GRADING AND EROSION CONTROL DOCUMENTS FOR HONOR CHARTER SCHOOL

EPC STORMWATER REVIEW COMMENTS
IN ORANGE BOXES WITH BLACK TEXT

GEC COVER SHEET
HONOR CHARTER SCHOOL
HIGHMARK SCHOOL DEVELOPMENT
8250 BENT GRASS MEADOWS DR.

G-3
OF
14

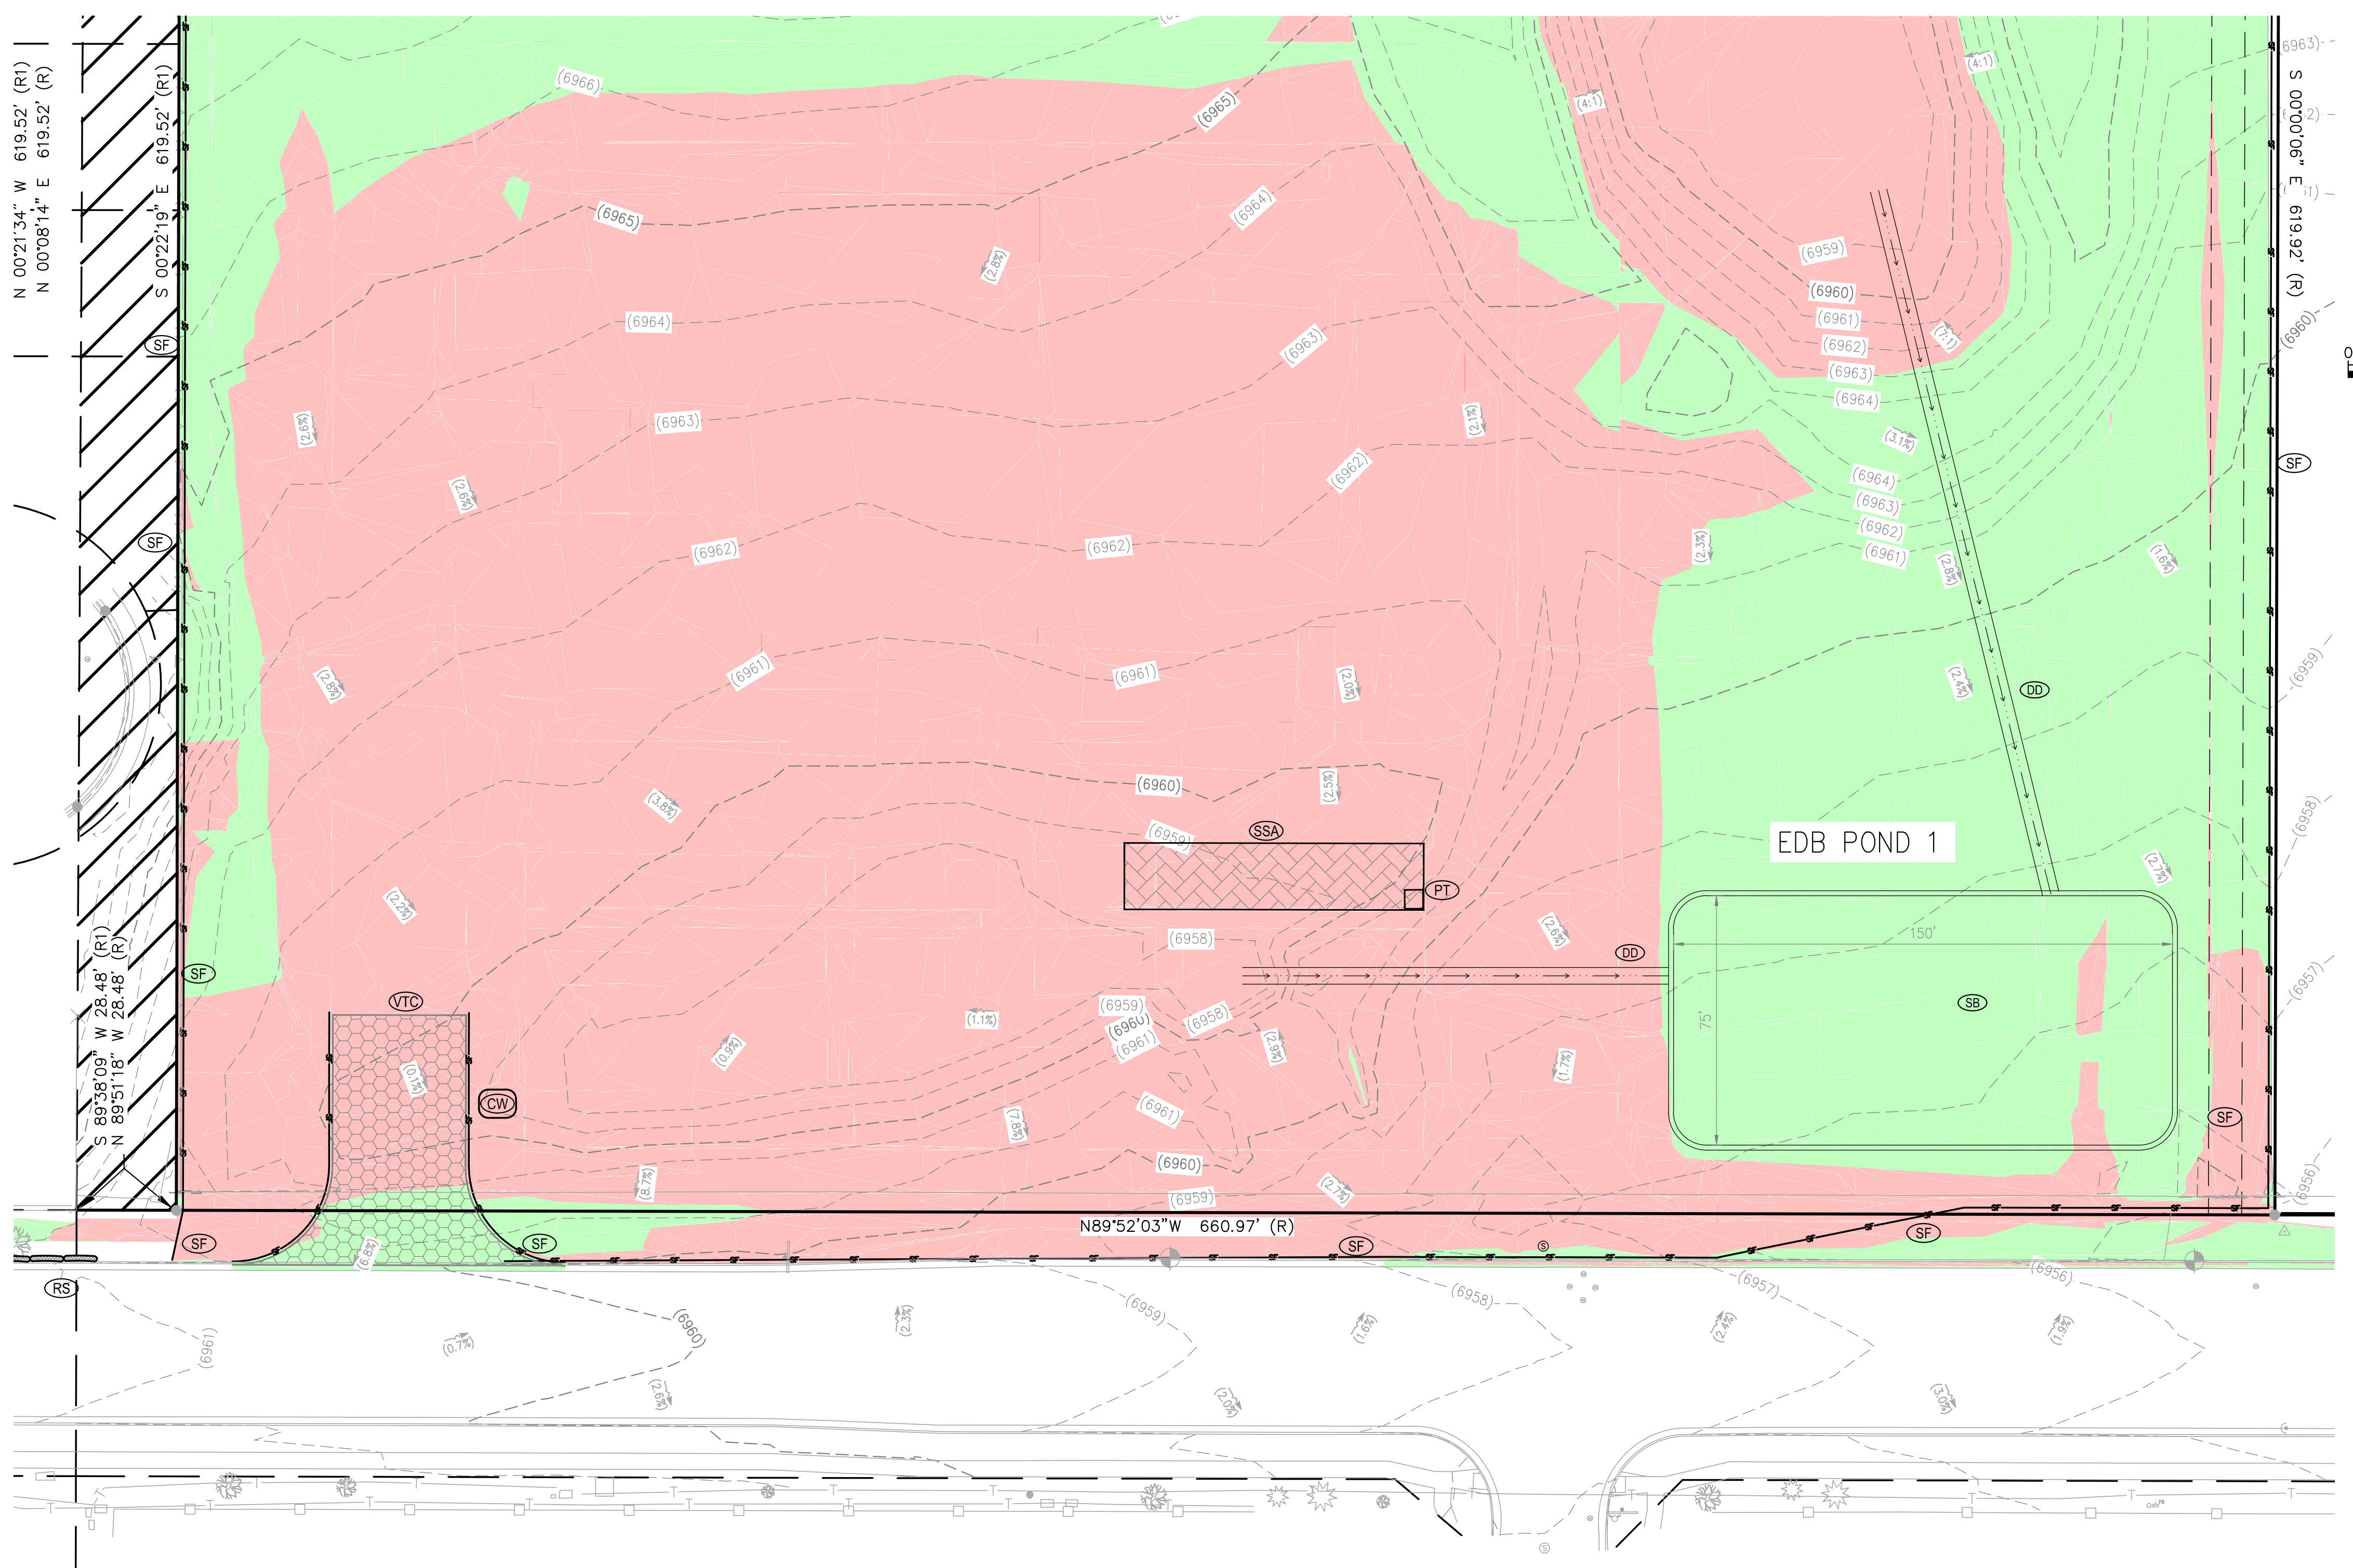
GEC Checklist Items L. If "limits of disturbance" and "construction boundary" are the same, change to "limits of construction/disturbance" or otherwise show as separate line types for each on the legend and figure.

GEC Checklist item K. Show existing vegetation (notes are acceptable in cases where there is no notable vegetation, only grasses/weeds, or site has already been stripped)
